12 August 2011

**Modification of Consent under Section 75W, EP&A Act
Major Project Approval No.09_0039
157 Redfern Street, Redfern - Redfern RSL Project**

PATH	C:\Arch\00 Jobs\DEI00308\DEI00308_DA-S96 Model (Mail Link)_sheet 110805.rvt	JOB No.	DEI00308
TITLE		DATE	Aug 2009
		SCALE	@ A1 As indicated
		DWG No.	DA112 K

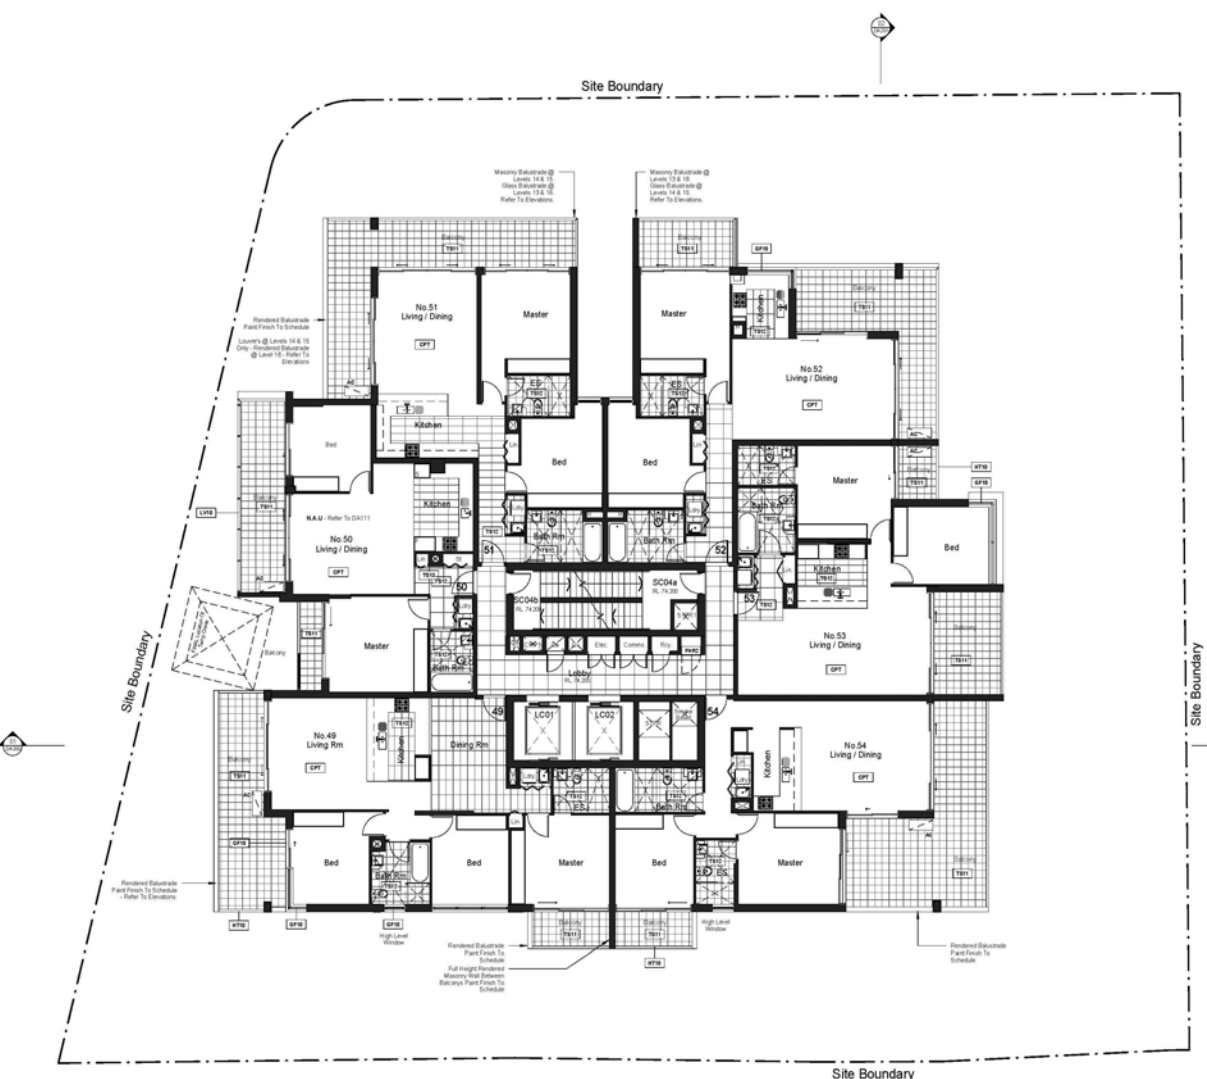
It is proposed to convert the 3-bedroom apartment in the south-western corner of Level 13 of the building into 2 x 1-bedroom dwellings.

The dwellings are to replicate the apartments approved above them at Levels 14 to 17, inclusive.

This modification can be facilitated without any change to the approved external profile of the building and will increase the overall number of apartments in the building from eighty-eight (88) to eighty-nine (89).

- amending the plan reference relating to Level 13 from Drawing No.DA 112 J to Drawing No.112 K, a plan which shows the conversion of the 3-bedroom apartment into 2 x 1-bedroom apartments; and
- amending the plan reference relating to Level 3 from Drawing No.DA 102 H to Drawing No.102 J, a plan which shows the proposed covered area.

Mall Link Plan (Combined)

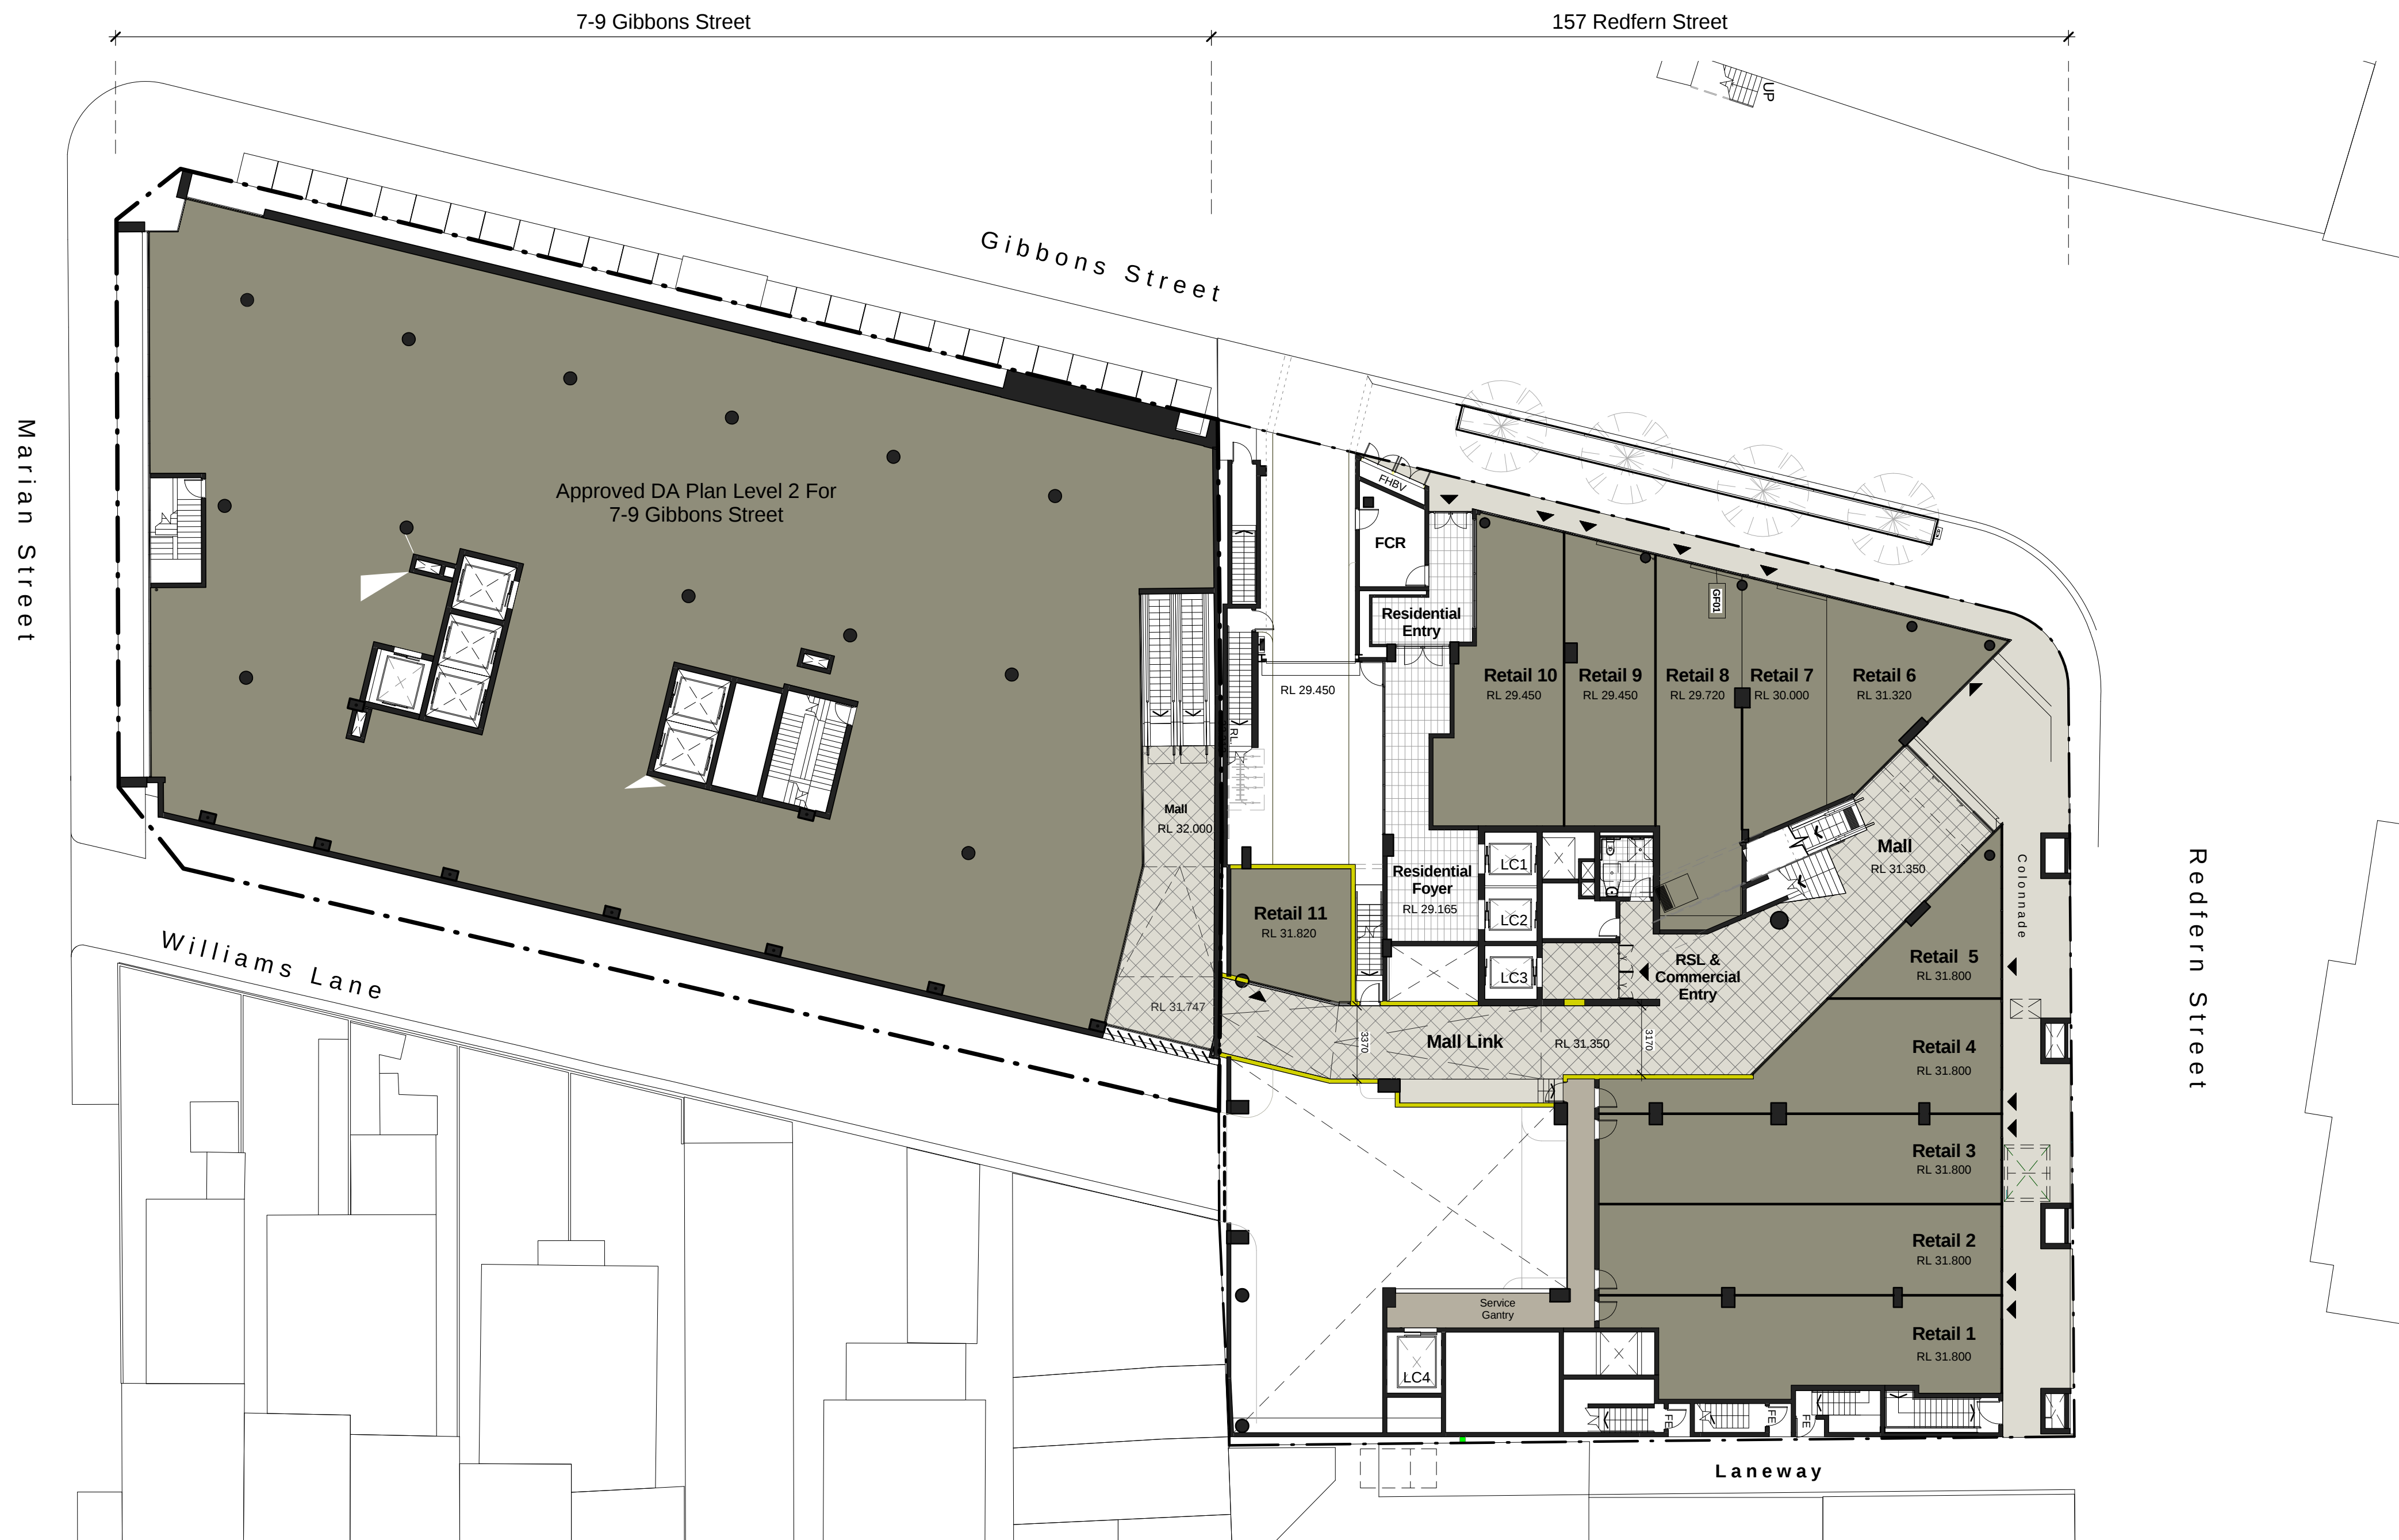
The joint ownership of the two (2) sites provides a unique opportunity to make minor amendments to the ground floor level of the building on 157 Redfern Street to provide a near level arcade linking the supermarket on 7-9 Gibbons Street to Redfern Street.

The arcade is to be achieved by adjusting and extending the approved access to the RSL Club and adjusting one of the approved retail areas fronting Redfern Street.

This floor area is to be replaced with a small retail area fronting the arcade closer to the supermarket to provide an active frontage along the arcade.

- amending the plan reference of the ground floor level - Level 1 from Drawing No.DA 100 H to Drawing No.100J, a plan which shows the proposed arcade; and
- adding a new plan reference, Drawing No.DA 165A, a plan which shows the connection of the arcade to the supermarket approved on 7-9 Gibbons Street;
